RESPONSE TO SUBMISSIONS

SCEGGS Darlington -
Modification 3
SSD-8993-Mod-3

This Submissions Report relates to a Section 4.55(1A) Modification application in relation to the Concept State Significant Application (concept SSD 8993) for SCEGGS main school campus located at 215 Forbes Street, Darlinghurst (**the site**). On behalf of SCEGGS Darlinghurst Limited (**the Applicant**), this Submissions Report has been prepared to address the matters raised by public agencies, local Council, the community and other relevant stakeholders throughout the public exhibition period.

3 EXISTING VIEW FROM NORTH EAST

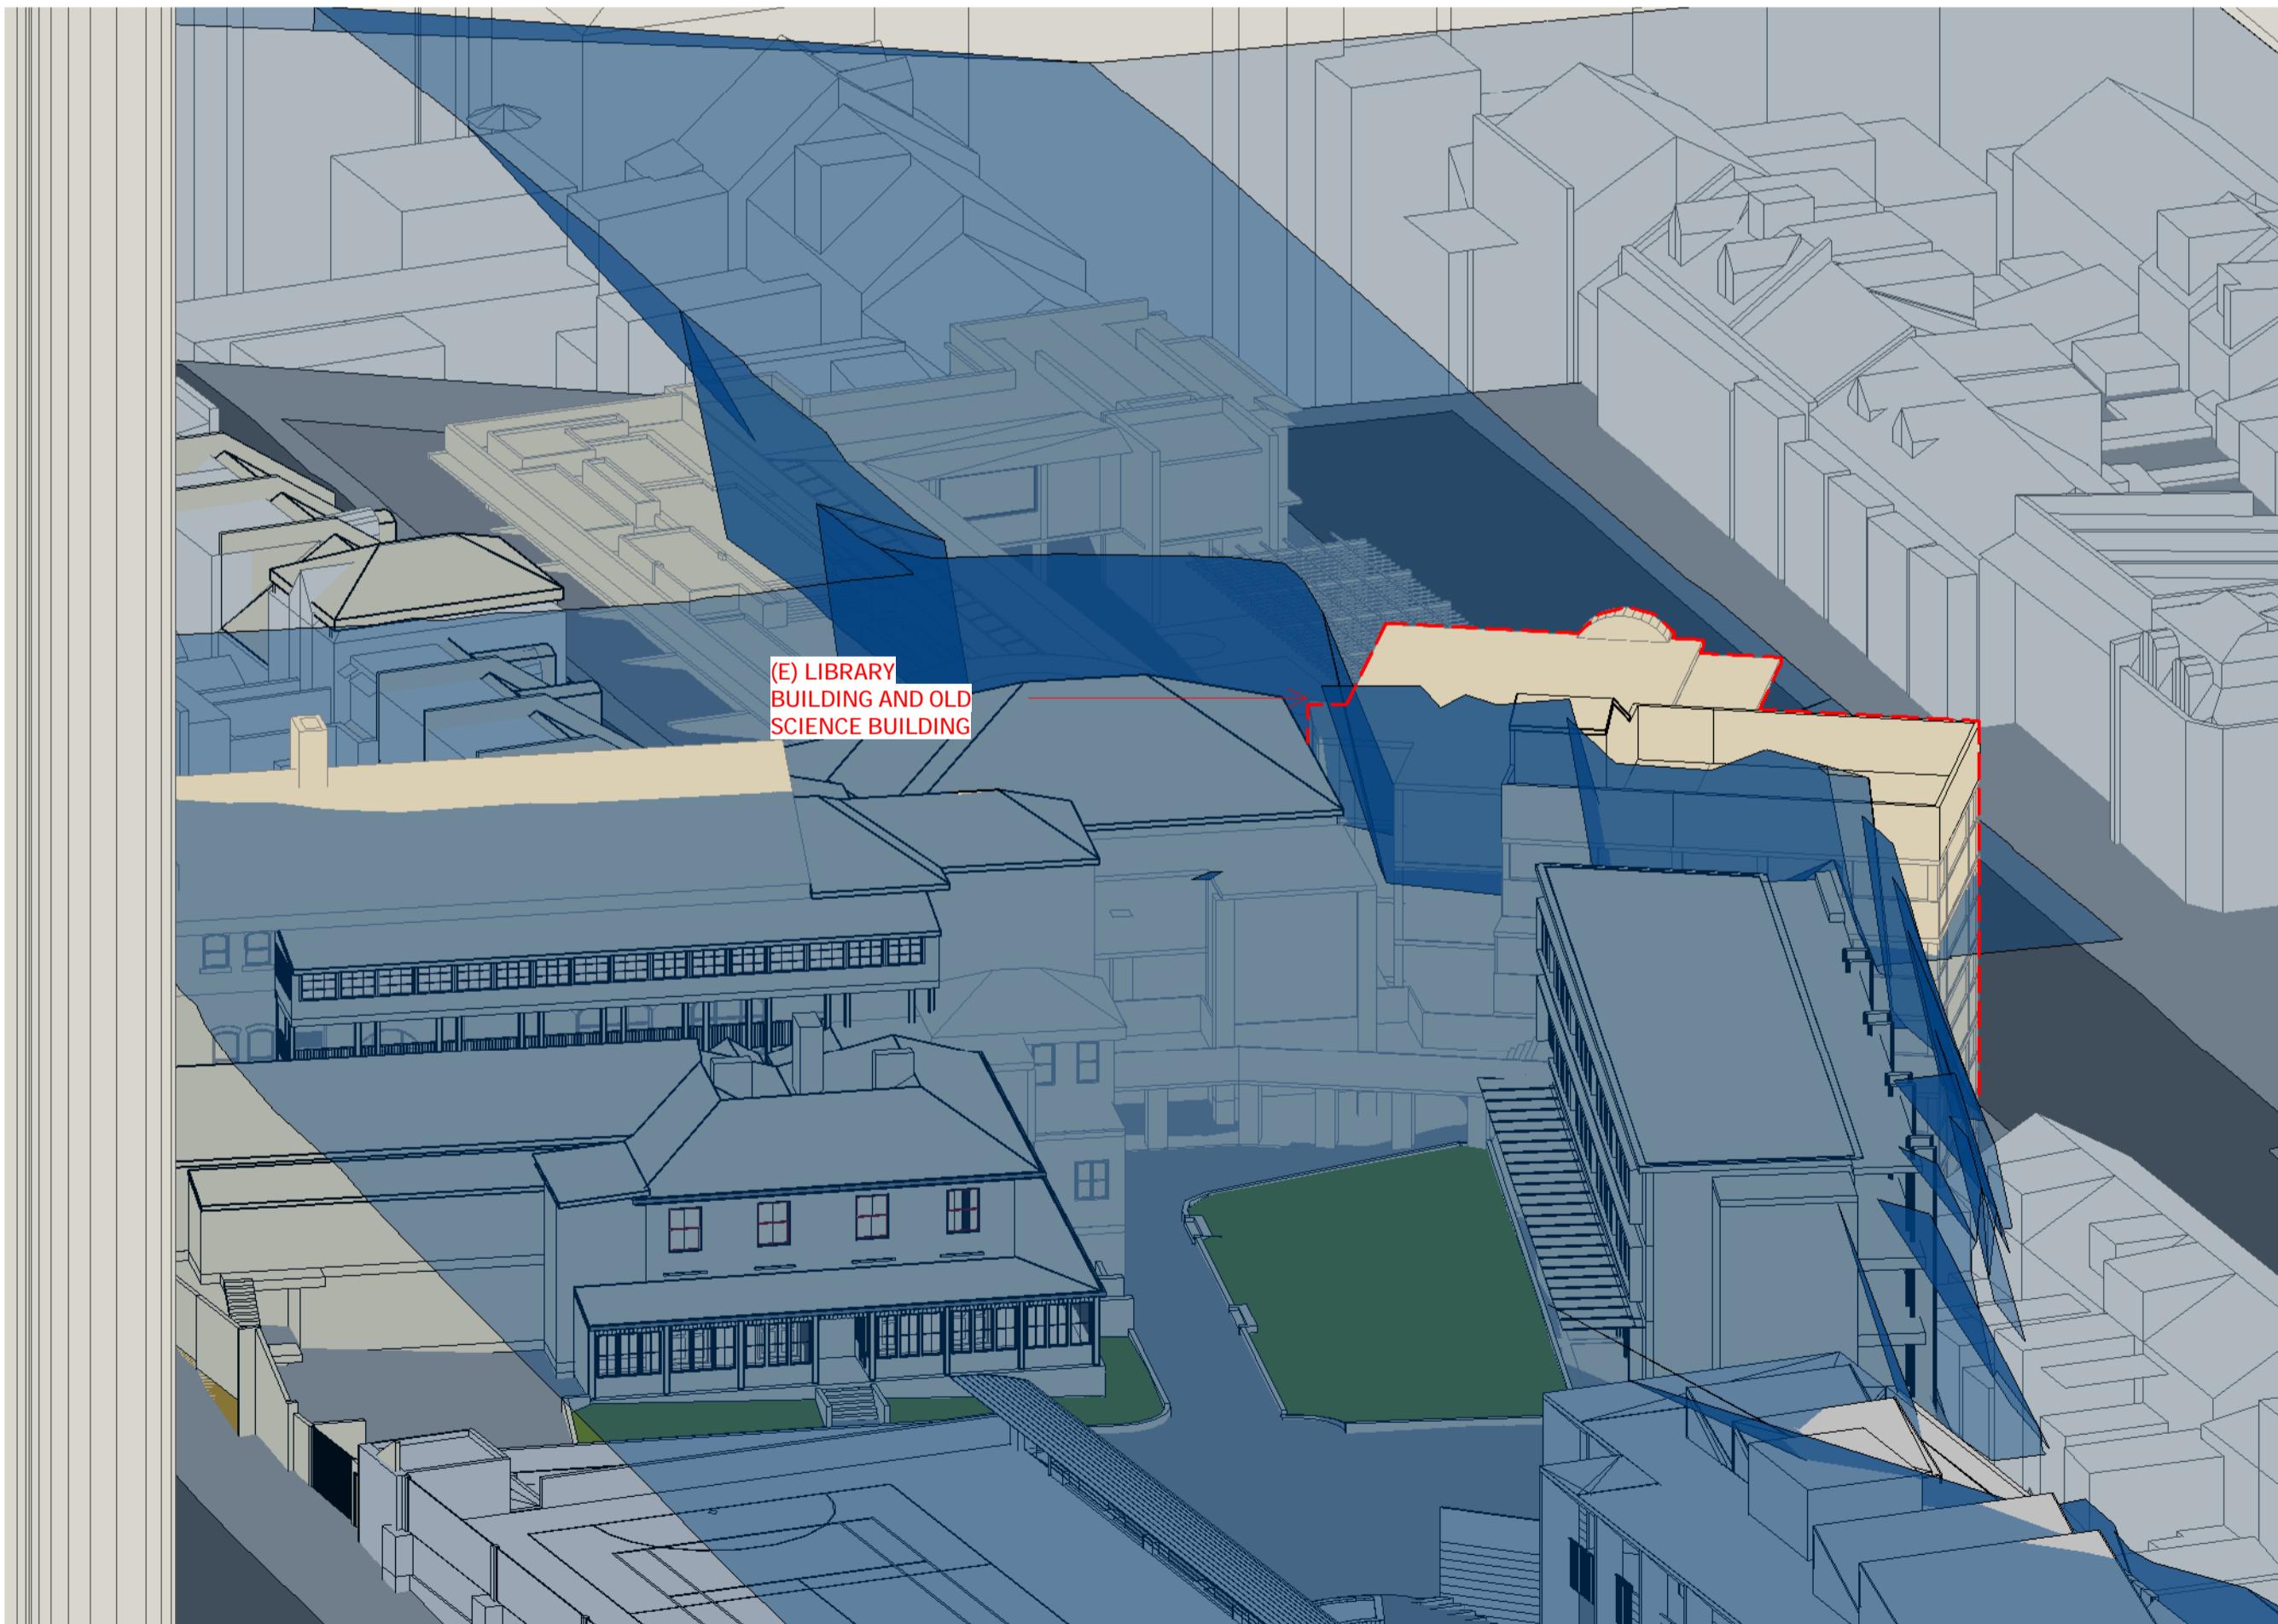
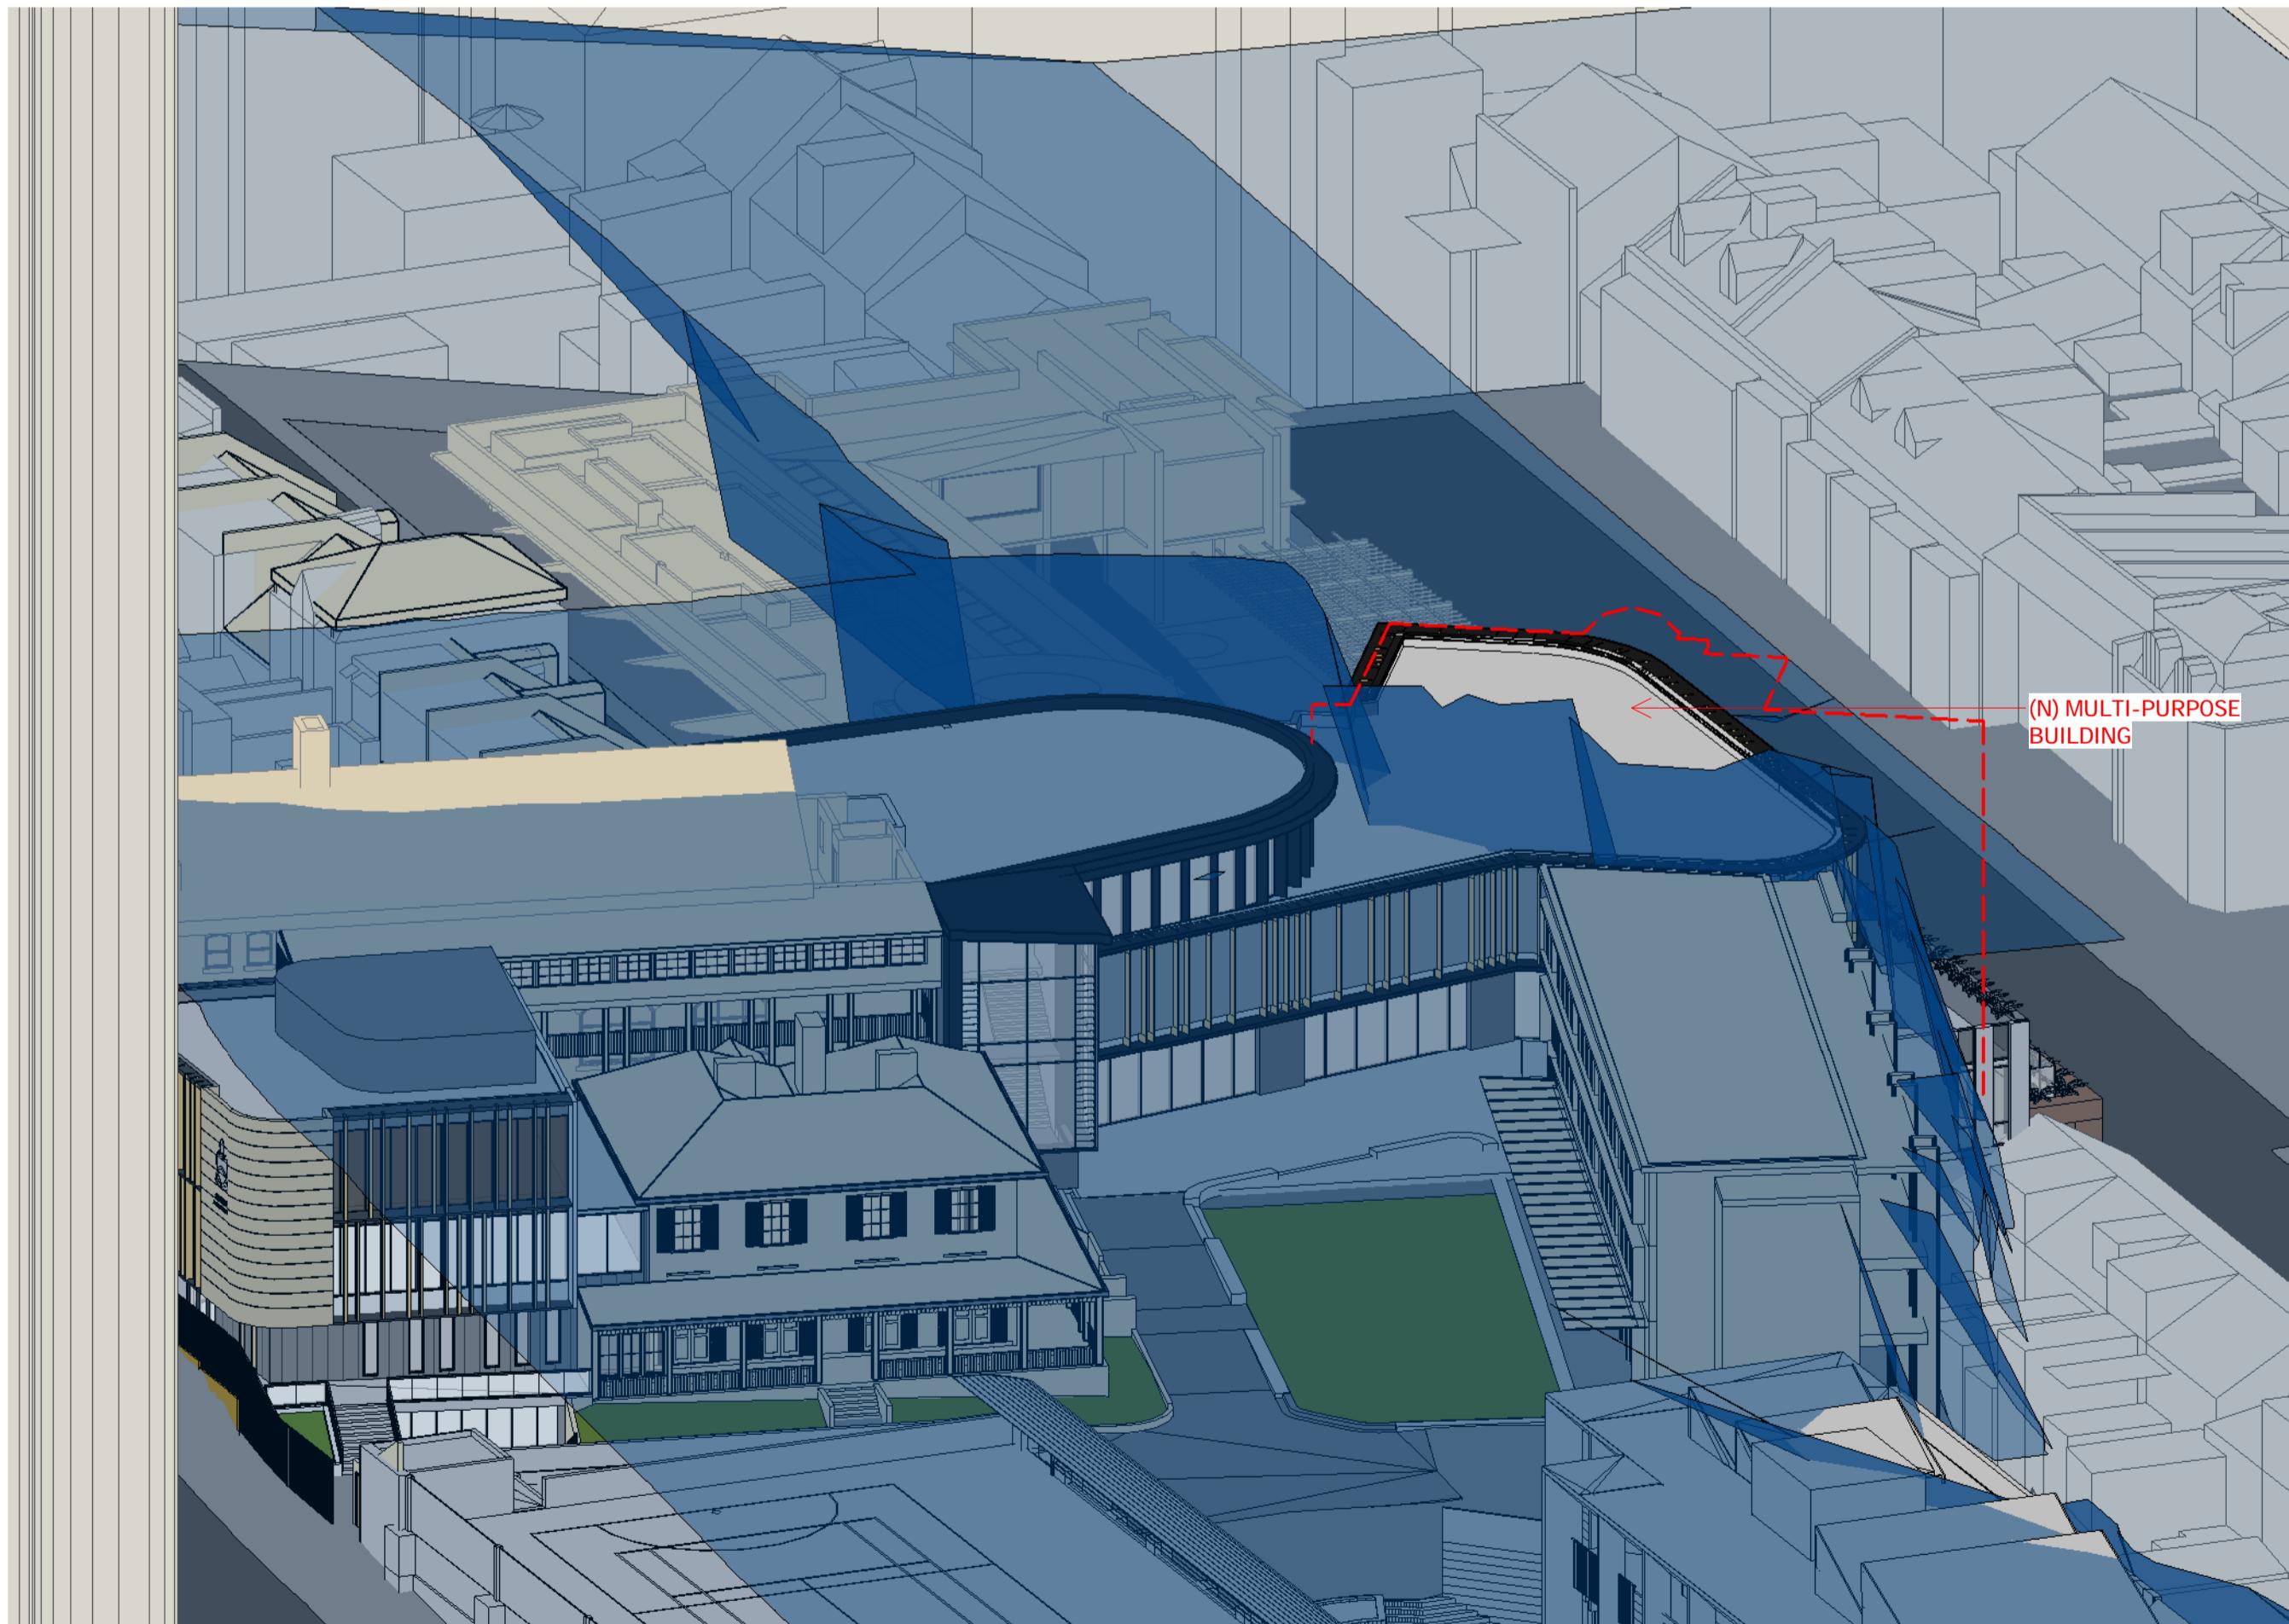
4.2. VISUAL IMPACT OF THE PLANT ENCLOSURE EXTENSION ON THE ROOF OF JOAN FREEMAN BUILDING

The proposal comprised a minor western extension of the building envelope for Wilkinson House to extend above the roof of Joan Freeman building to allow for a plant enclosure for condenser units (as proposed under the concurrent SSDA for Wilkinson House). It is important to clarify that the extension is located on top of the fire staircase portion of the Joan Freeman building (not the main portion of the building), which is further setback from the main façade of the Joan Freeman building.

The building envelope extension has a maximum RL of 45.77, which matches the maximum height of the existing Joan Freeman building (refer to Figure 2). The height of the extension is slightly below the proposed building envelope height of Wilkinson House.

The proposed envelope extension will not be readily visible from the street, because:

- A height datum has already been established by the existing carpark exhaust riser of the Joan Freeman Building, so the envelope extension will blend in with existing service structure.
- The location of the envelop extension is setback from the street and the envelope of Wilkinson House and Joan Freeman building. Therefore is not easily perceived from the street.
- The detailed design of the plant enclosure within the envelope extension is shown in the Detailed SSDA for Wilkinson House. The plant enclosure will be screened, using dark brick treatment to ensure its recessive character.

The proposed envelope extension will not create any adverse visual impact from the street and is considered to be acceptable.
